re: Geotechnical Grading and Site Servicing Plans Review
Proposed Industrial Development
295 Roger Neilson Way - Ottawa, Ontario

date: August 27, 2026

file: PG7845-MEMO.02

Figure 2: Proposed Grading Plan for Proposed Works at 295 Roger Neilson Way (EGIS, 2026).

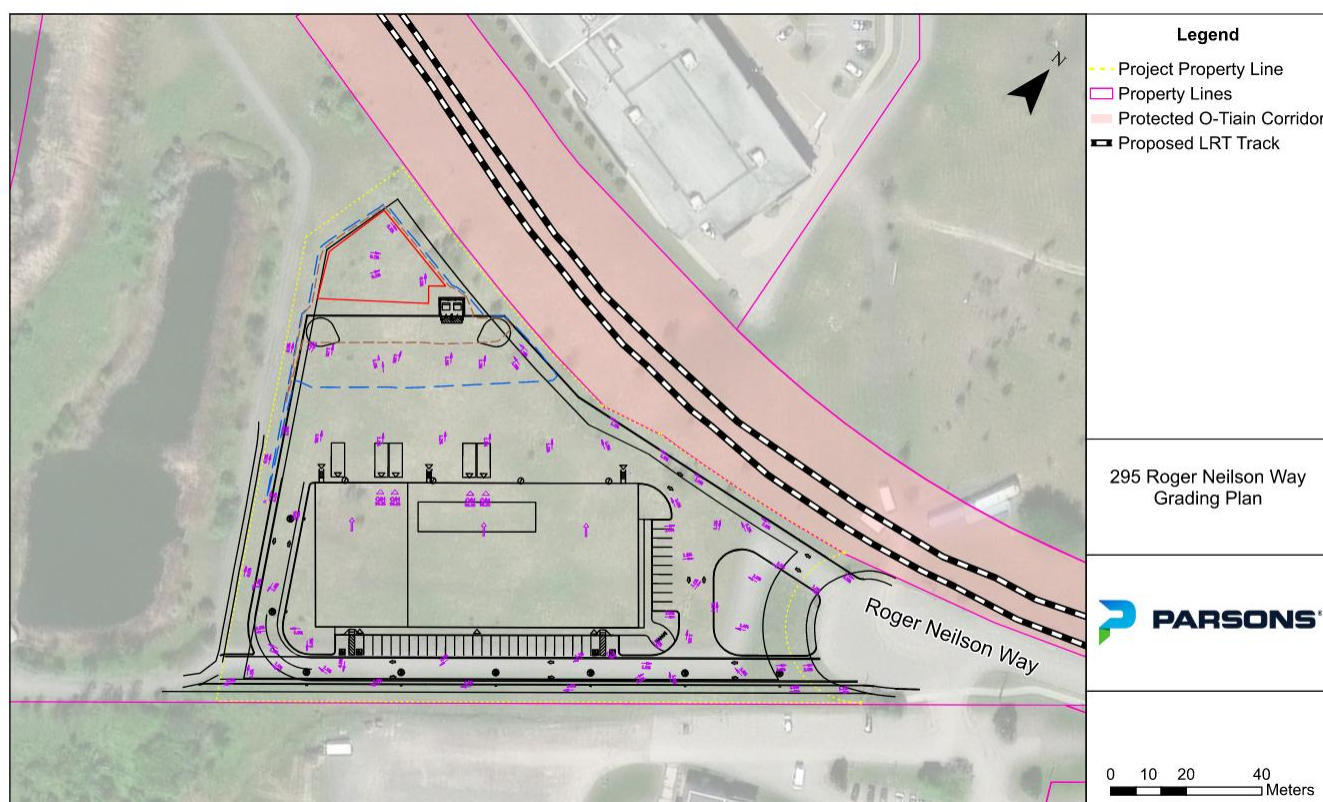
Paterson has reviewed the subsurface conditions within the footprint(s) of the proposed building. Based on our review, **a permissible grade raise restriction of 0.5 m** is recommended in the proposed building footprint and within 3 m of the building perimeter. This accounts for a live load on the slab-on-grade of 12 kPa. If the actual live load on the slab-on-grade differs from this value, then this permissible grade raise value would need to be adjusted. Beyond the 3 m distance from the proposed building perimeter, **a permissible grade raise restriction of 1.2 m** is recommended.

Based on our review of the above-noted drawing, the proposed grading for the parking areas, access roads, and landscaped areas beyond 3 m of the proposed building footprint is within the permissible 1.2 m grade raise. However, based on the finished floor elevations and proposed grading around the building, lightweight fill (LWF) should be placed below and around the proposed building footprint. The LWF should be installed at the minimum thickness, locations, and extents shown on Figure 2 attached to this memorandum.

Reference should be made to Figure 1 – EPS Block Installation Recommendations and Figure 2 – Marked-Up Grading Plan, which indicate the required locations, extents, and thicknesses of the LWF.

It shall be noted that the LWF shall not extend vertically below the USF. The LWF should consist of EPS (expanded polystyrene) geofoam blocks, which allow for raising the grade without adding a significant load to the underlying soils. For this application, EPS type 15 should be used.
